2025/0443

Proposed alterations including ground floor bathroom fixtures, infills and openings to the family room and utility room, reposition bathroom wall, and, window and door replacement (Listed Building Consent)

Roper House, Roper House Lane, Thurgoland, Barnsley

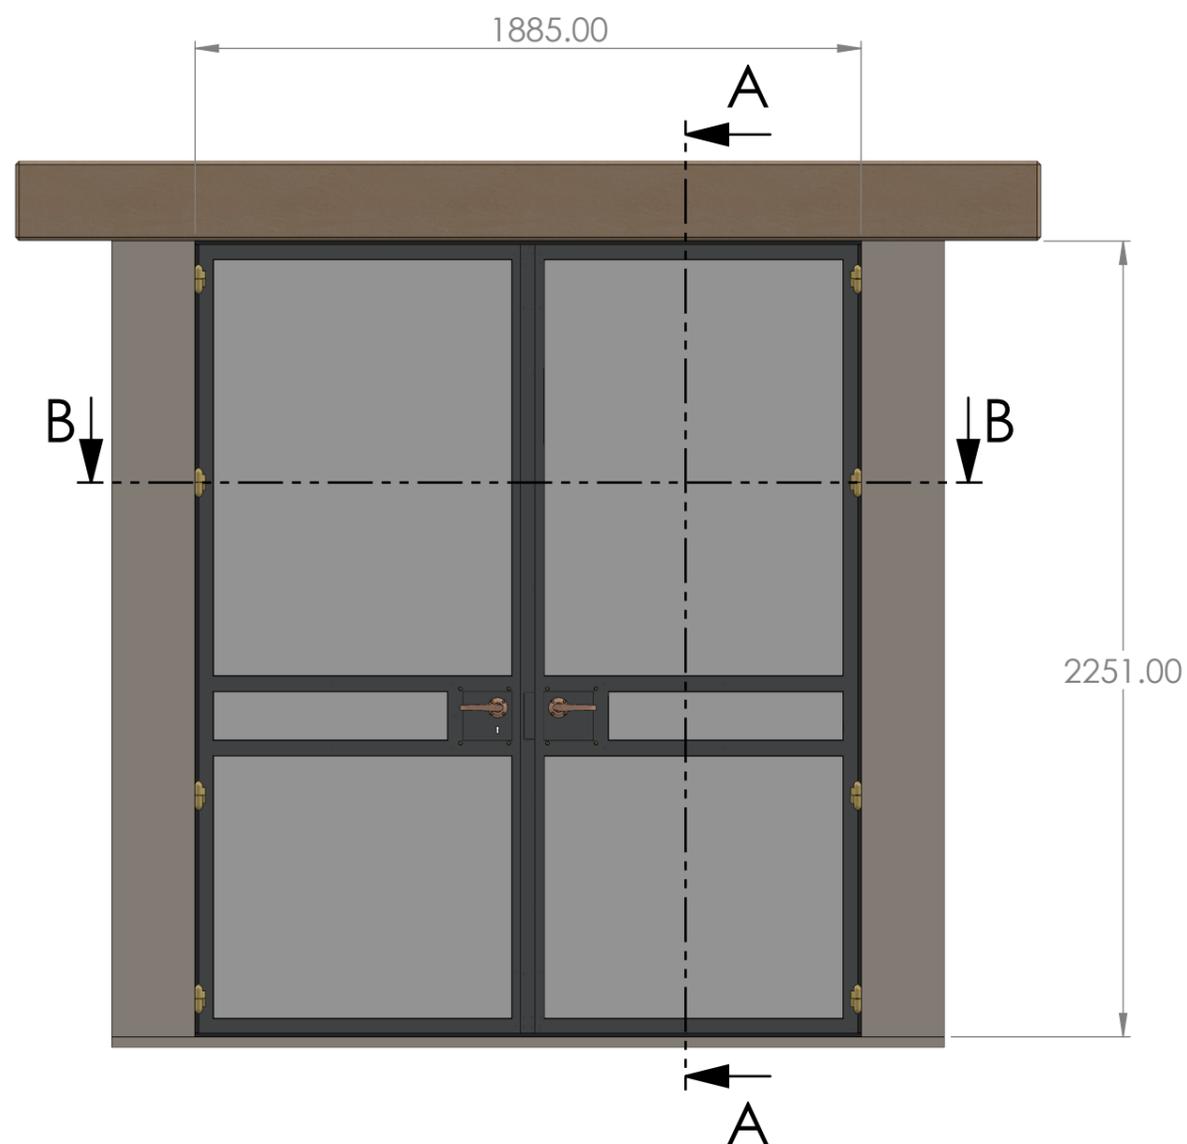
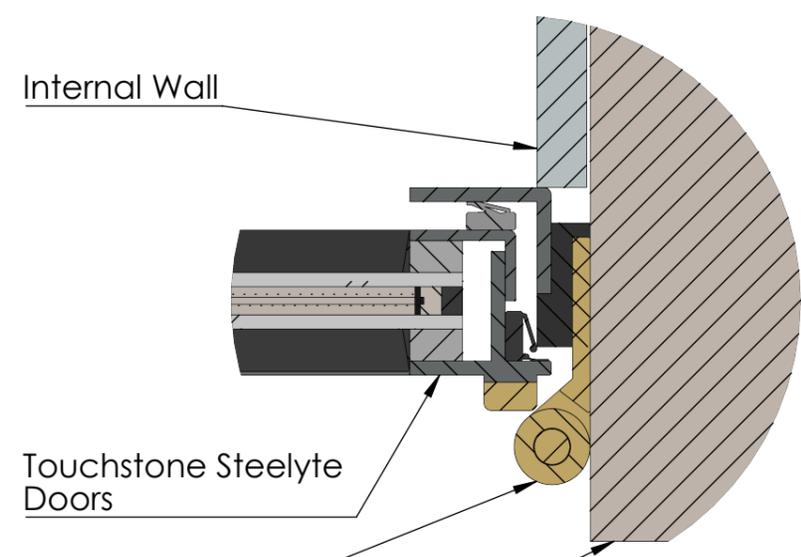
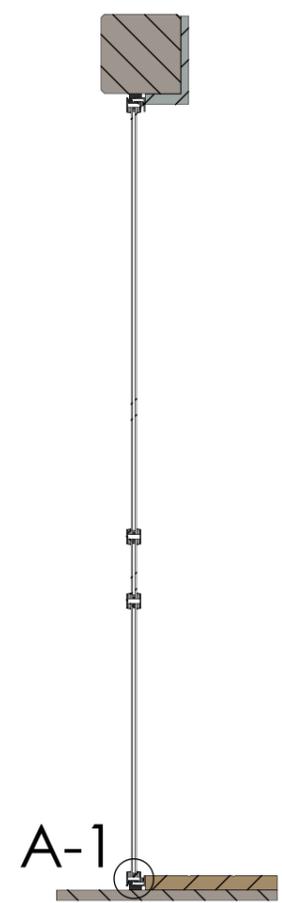
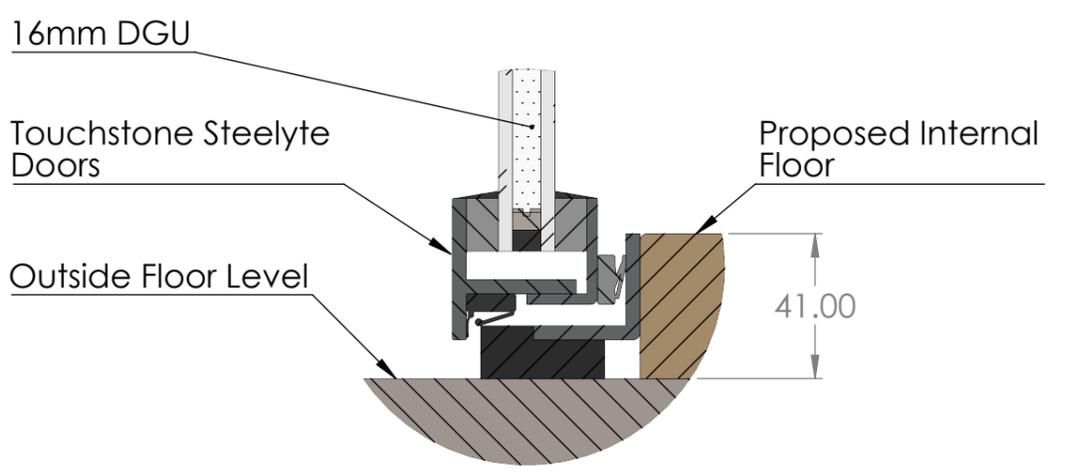
The rear family room double doors are to be replaced with timber doors (some painted, others stained) to improve energy efficiency and watertightness. Two options are presented: • Option 1: Lower and rebuild the floor to align with the doorframe. • Option 2: Retain or raise the existing floor to meet the doorframe, with a riser beneath. Both options propose a 16mm profile, consistent with the window proposal. From a conservation standpoint, Option 2 is preferable due to retention of existing fabric and floor levels, though both are acceptable in this instance.

**DWG TITLE**  
 PROPOSED ELEVATION PLANS

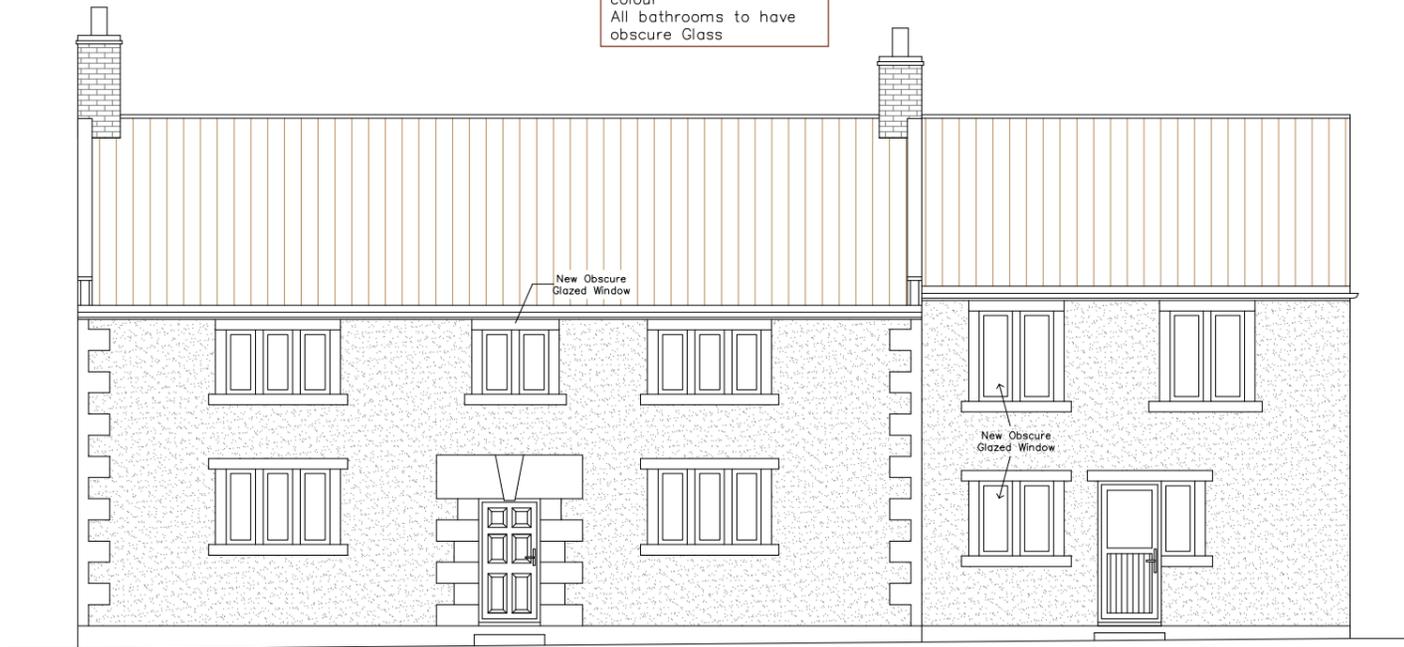
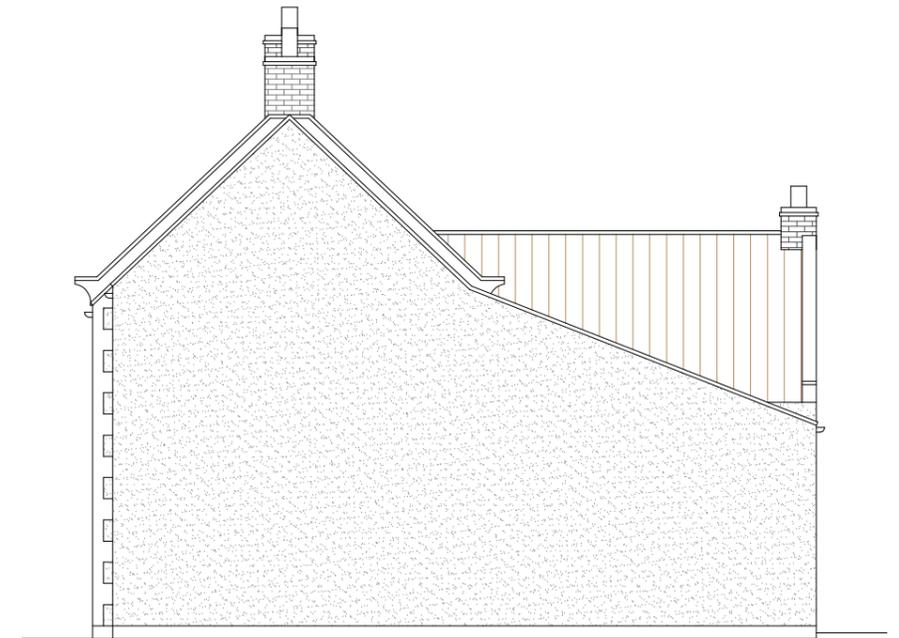
The proposal includes replacing the existing C20 replacement windows, which are currently inefficient and not watertight. The new windows will match the existing in size and profile, with a slimmer section (16mm compared to the existing 28mm), improving energy efficiency while remaining in keeping with the building’s character. The application specifies black frames, which pose no conservation concerns. Obscured glass is proposed for the downstairs and upstairs bathroom windows to match existing treatments and enhance privacy. There are no objections to the proposed window replacements or the introduction of obscured glass.

The proposed elevations suggest repainting the building to match the existing colour, seemingly white. A paint sample should be provided, however, if this is a like for like repair/ maintenance we could consider this to be acceptable and to be done without a sample. The repainting is understood to be an aesthetic improvement, which is considered acceptable.
